## KITTITAS COUNTY DEPARTMENT OF PUBLIC WORKS

### MEMORANDUM

**TO:** All Staff  
**FROM:** Public Works Plan Review Team  
**DATE:** May 23, 2024  
**SUBJECT:** SP-24-00007 Davenport

DAVENPORT SHORT PLAT

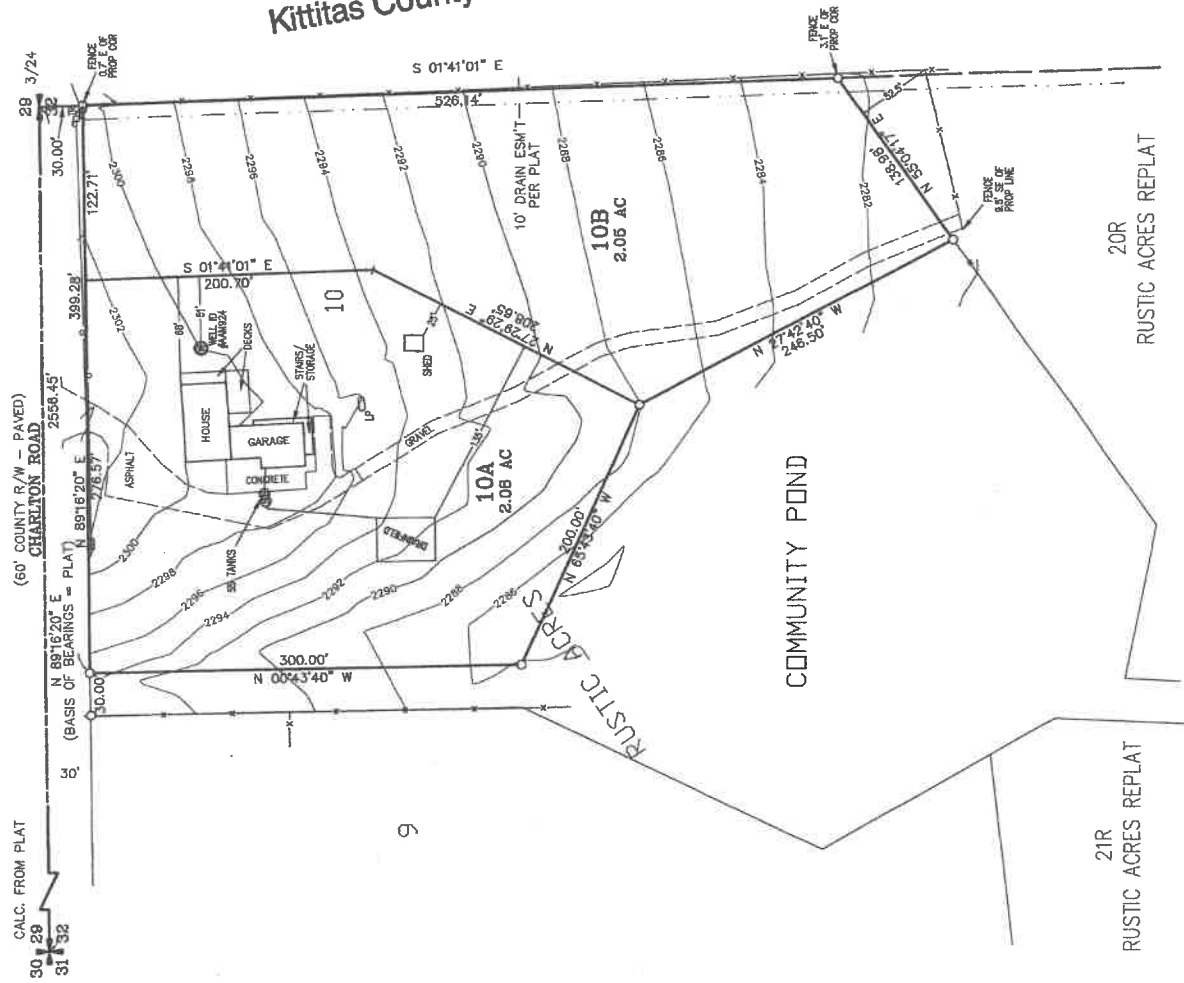
<b>ACCESS</b>	<ol style="list-style-type: none"><li>1. An approved access permit shall be required from the Kittitas County Department of Public Works prior to creating any new driveway access or altering an existing access.</li><li>2. Maintenance of driveway approaches shall be the responsibility of the owner whose property they serve. The County will not maintain accesses.</li><li>3. Any further subdivision or lots to be served by proposed access may result in further access requirements. See Kittitas County Road Standards.</li><li>4. In addition to the above-mentioned conditions, all applicable Kittitas County Road Standards apply to this proposal. Access is not guaranteed to any existing or created parcel on this application.</li></ol> <p>OFF NOTE:</p> <ol style="list-style-type: none"><li>5. Please ensure that the parcel with the existing home addressed as 700 Charlton Road retains the address upon final recording of short plat. (JS)</li></ol>
